V2_Drainage Report - Final_comments.pdf Markup Summary

FINAL DRAINAGE REPORT

ELK VIEW ESTATES

El Paso County, CO

EXISTING CONDITIONS
DRAINAGE MAP

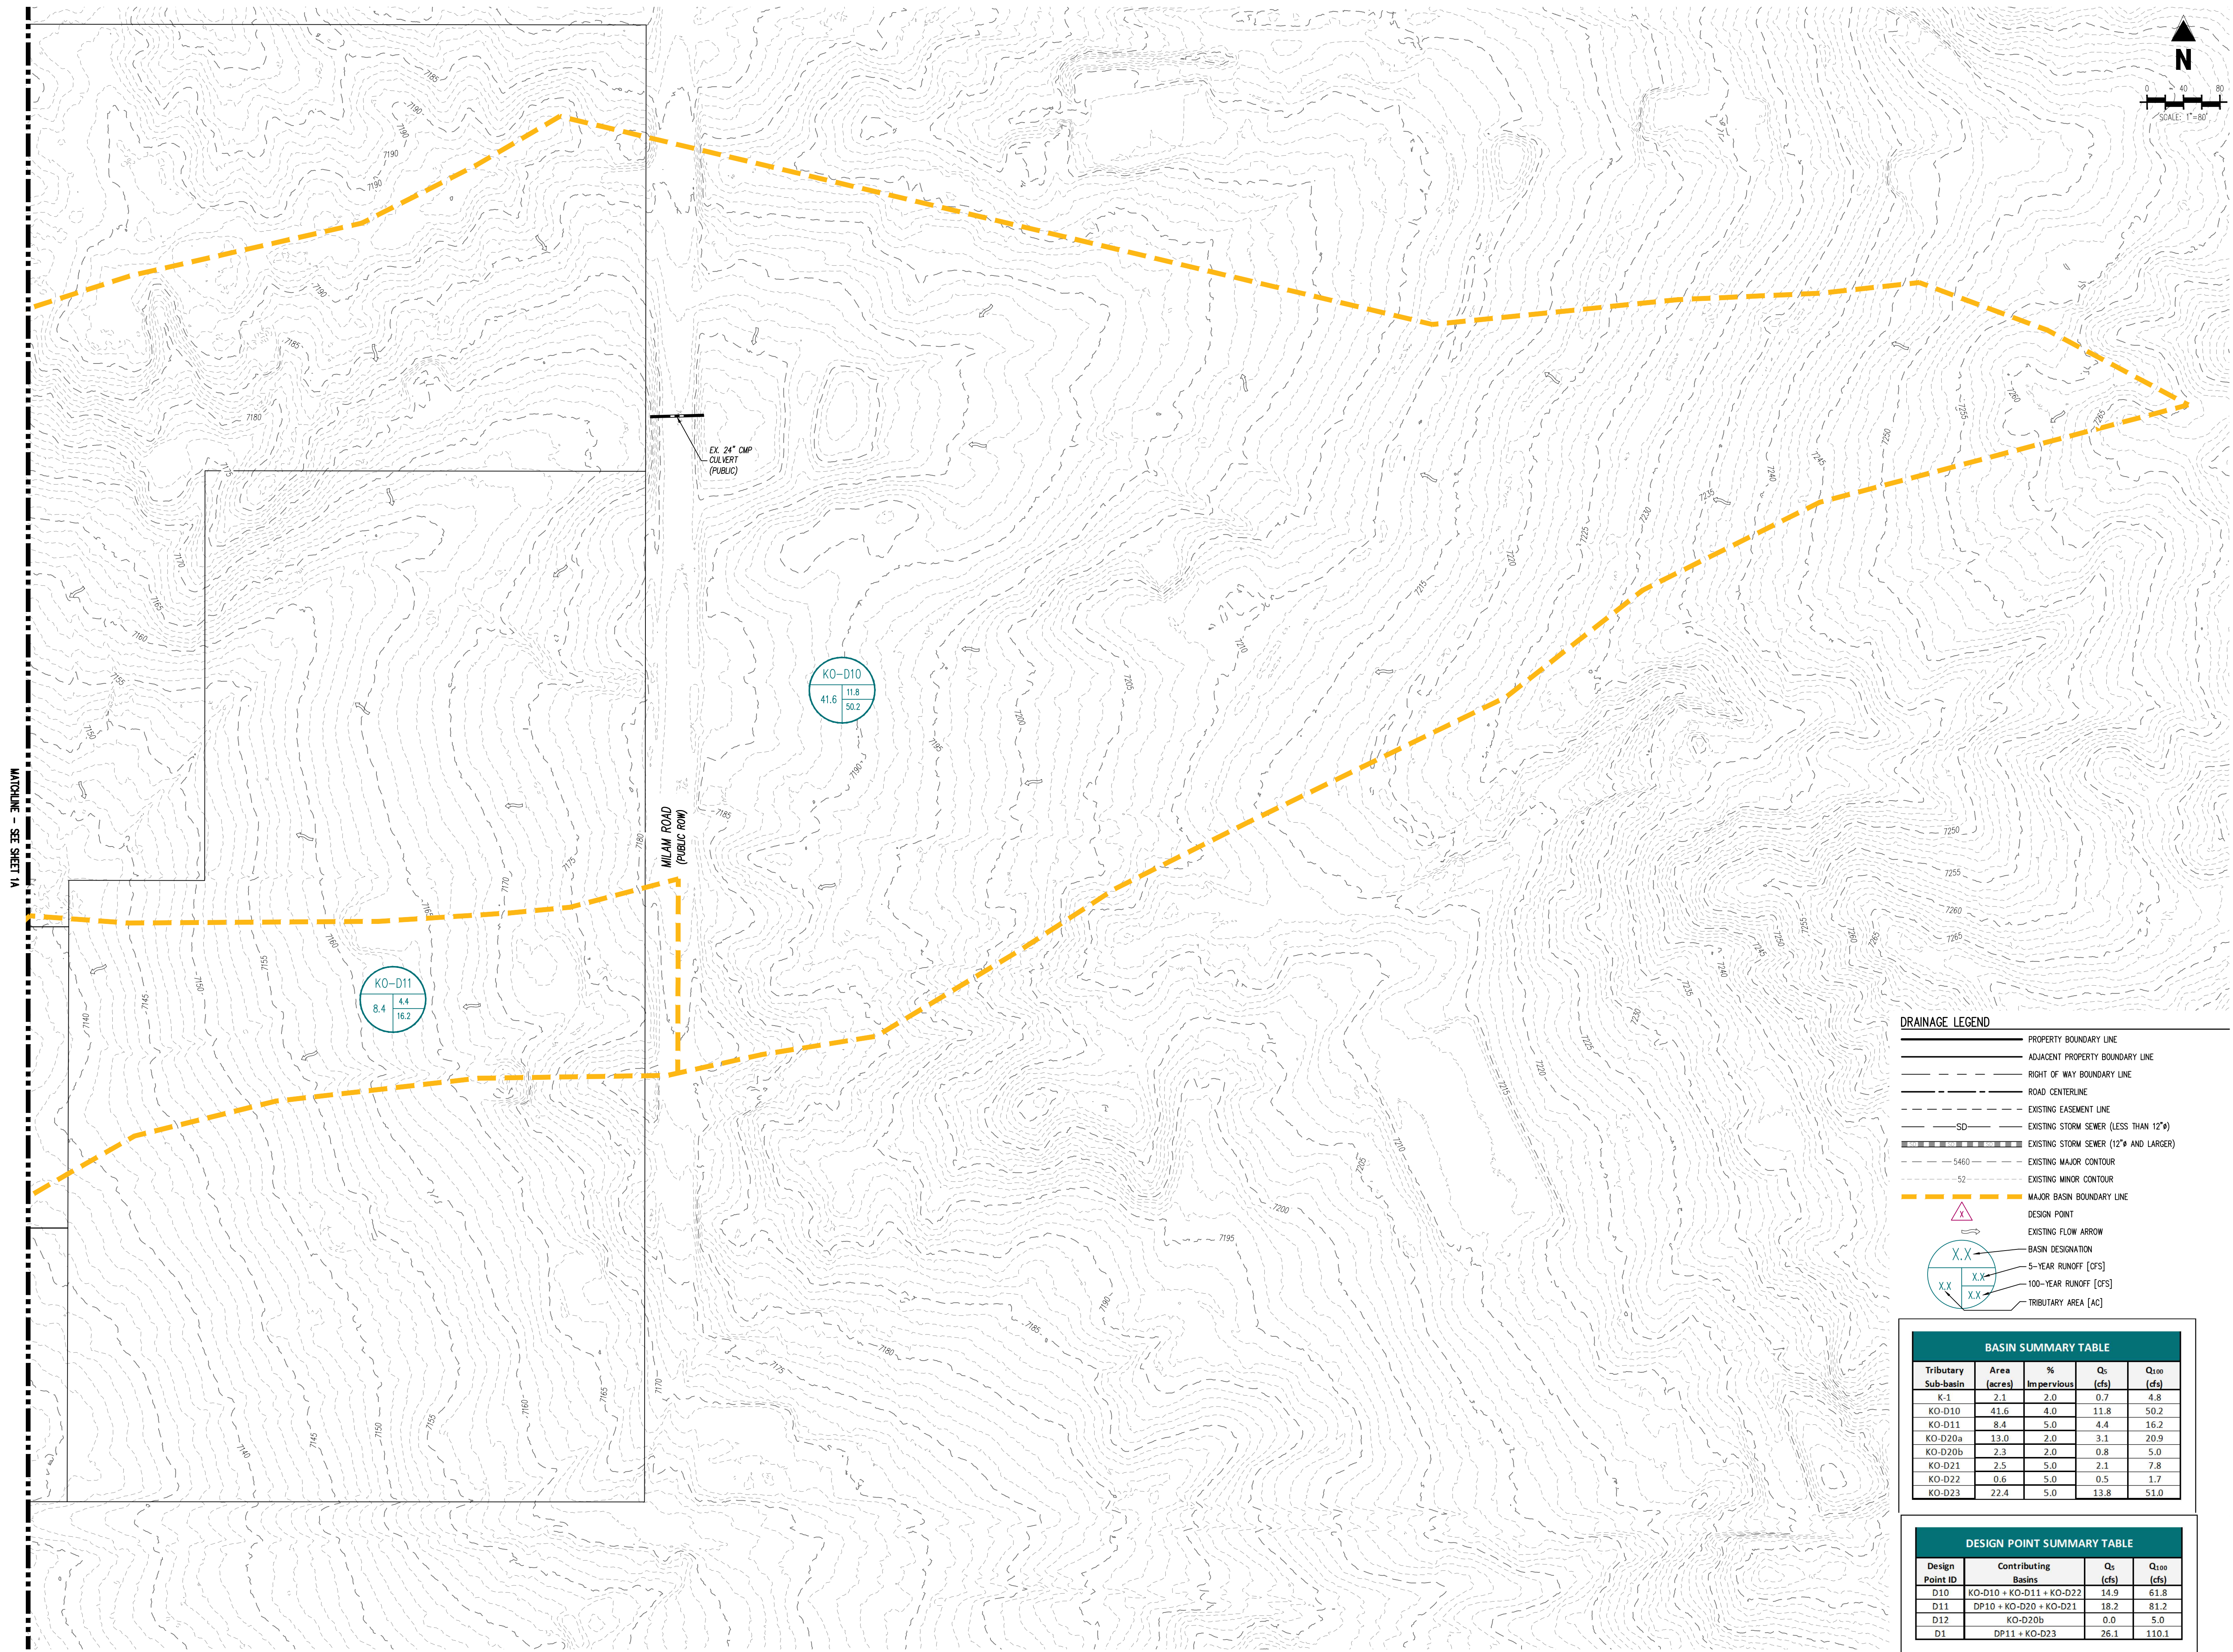
Unresolved:
Label & show existing swale. Provide easement

Unresolved:
Provide analysis of existing culvert and swale for comparison to proposed condition. Provide easement for swale

Unresolved:
Add basin line here to match with proposed

Unresolved:
Label easement

Unresolved:
Need a DP at this location for flows exiting site and to compare to proposed

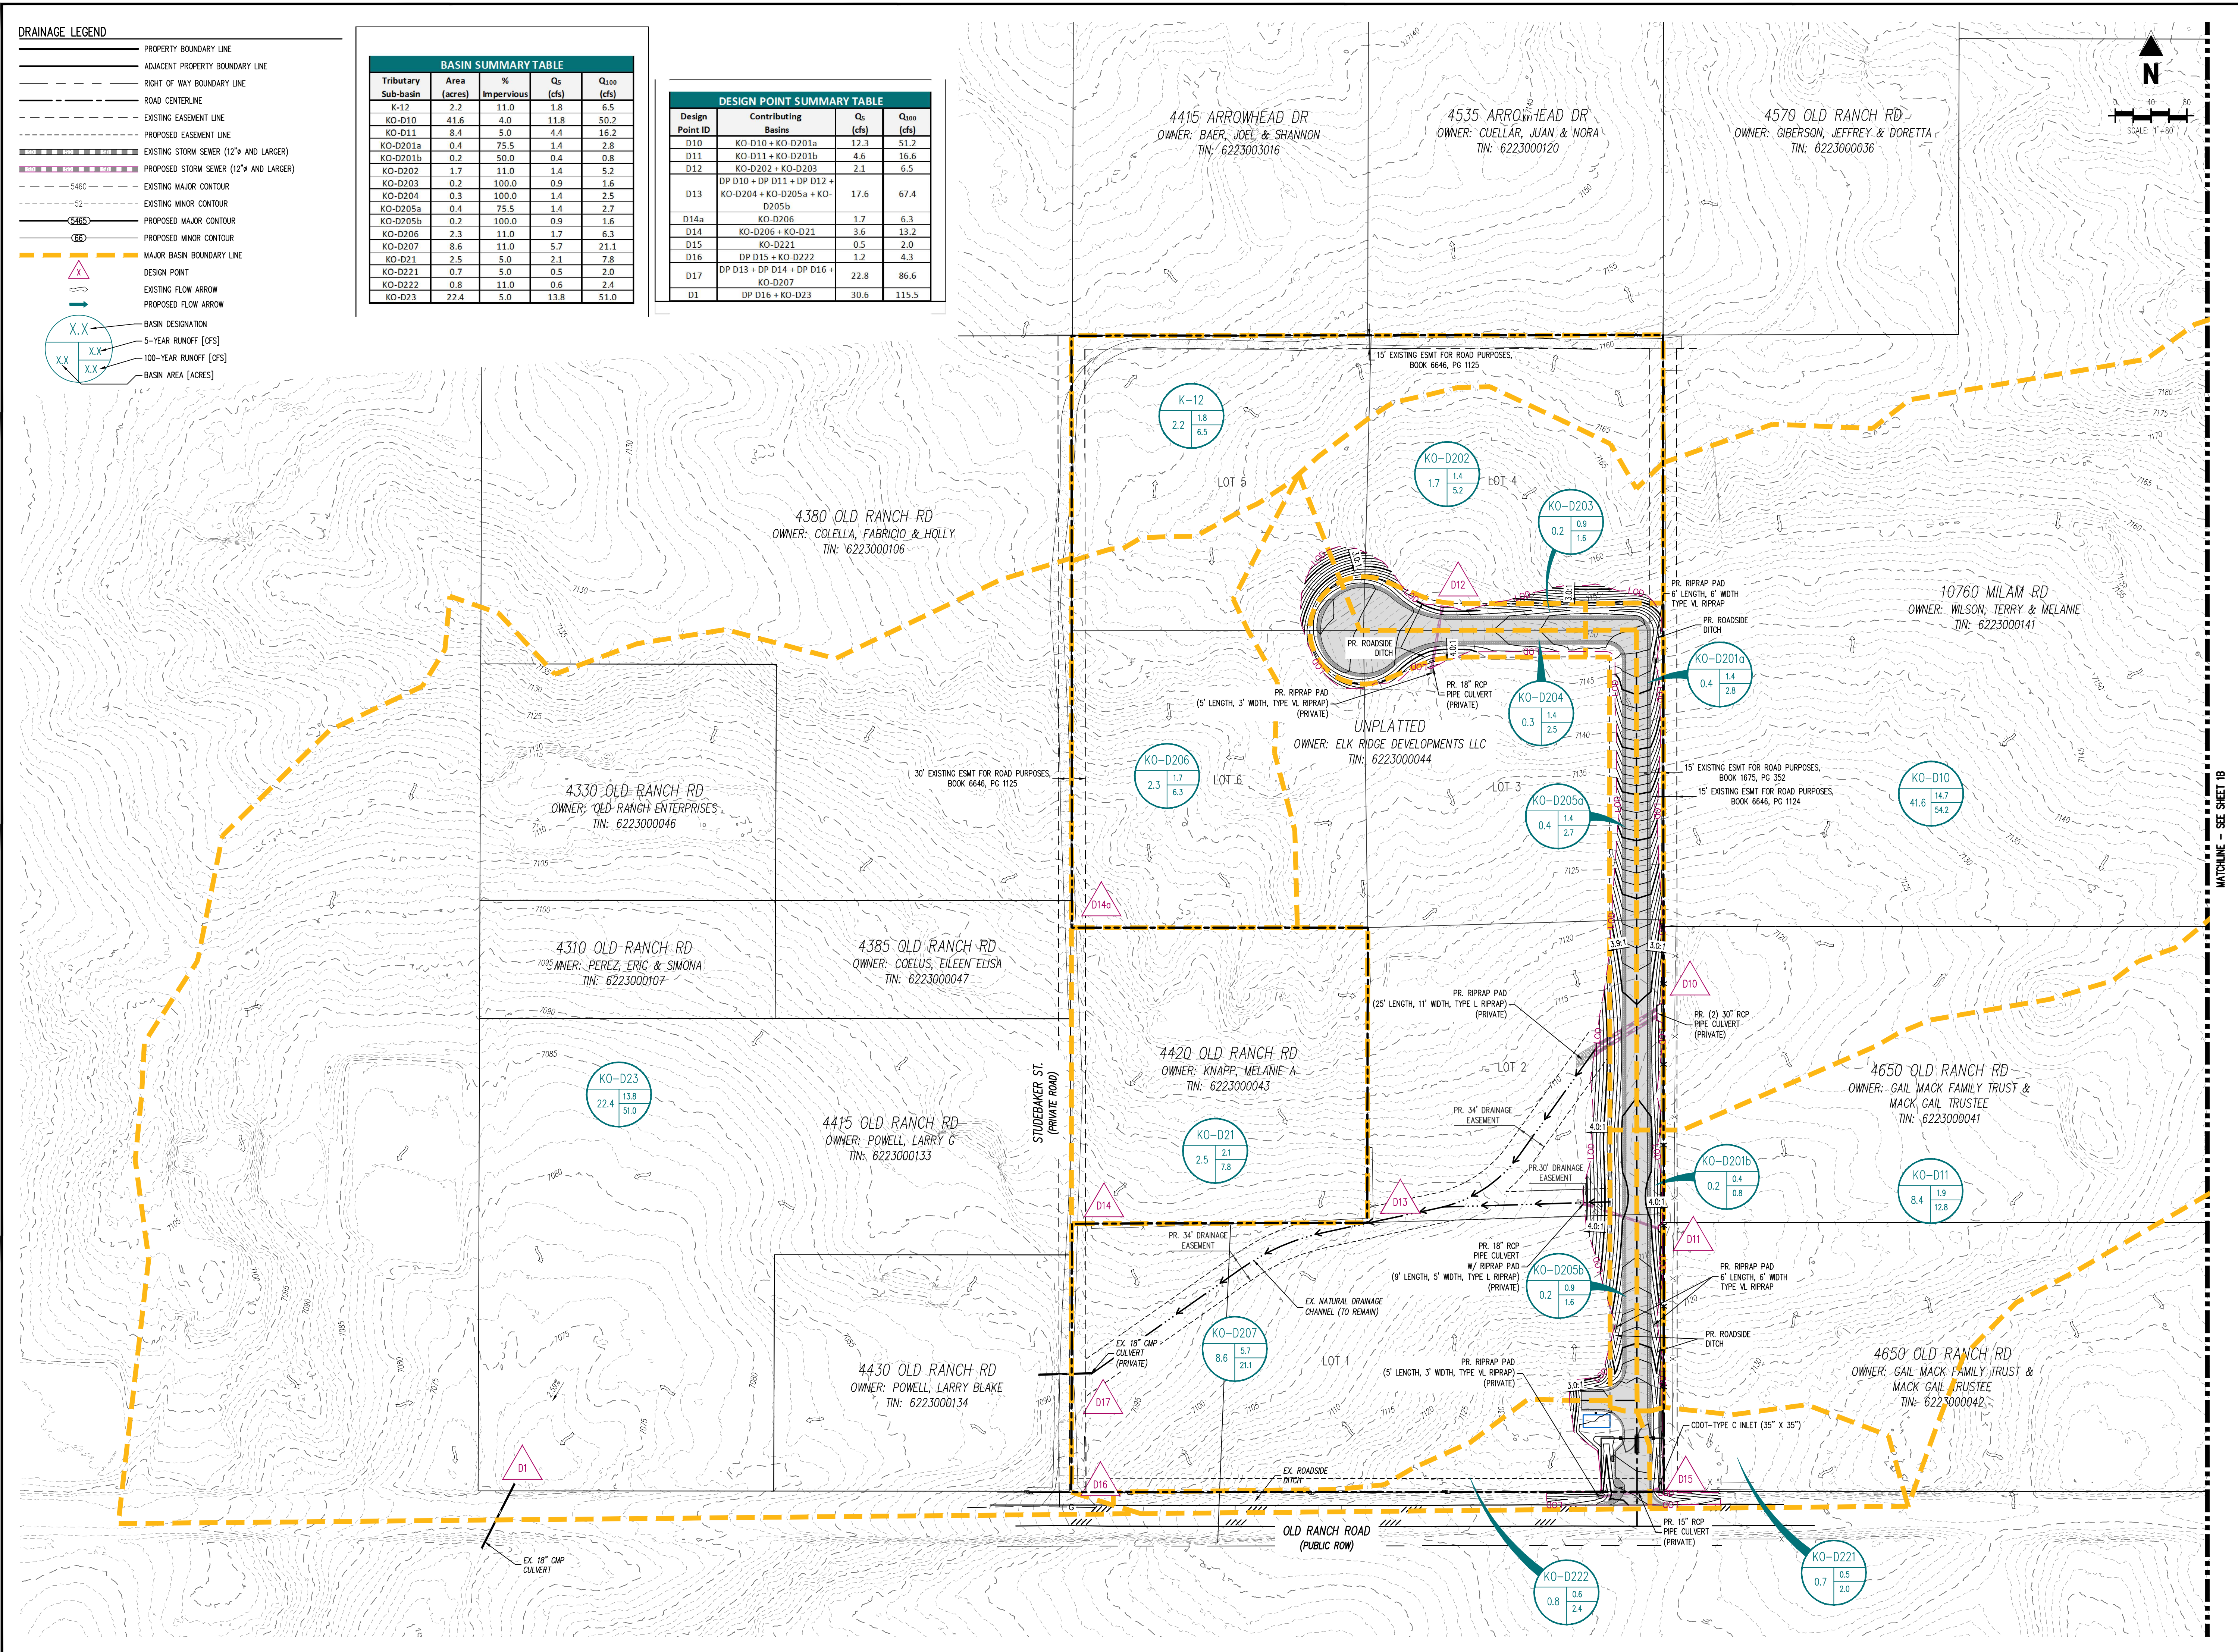
Unresolved:
Label all slopes

Unresolved:
Provide calculations for roadside ditches

Unresolved:
Label outlet protection at all proposed pipes

Unresolved:
Show and label path of concentrated flows from all proposed culverts. Provide easements for those swales and provide calculations in appendix

Unresolved:
Show and label Type C inlet

Label riprap pads. Provide discussion of their purpose in narrative and include design calculations in appendix.

For all RPAs, provide length and width dimensions. It needs to be clear what the exact min dimensions are for maintenance purposes. RPAs should be 80% vegetated.

Unresolved:
Need DP here as flows exit site
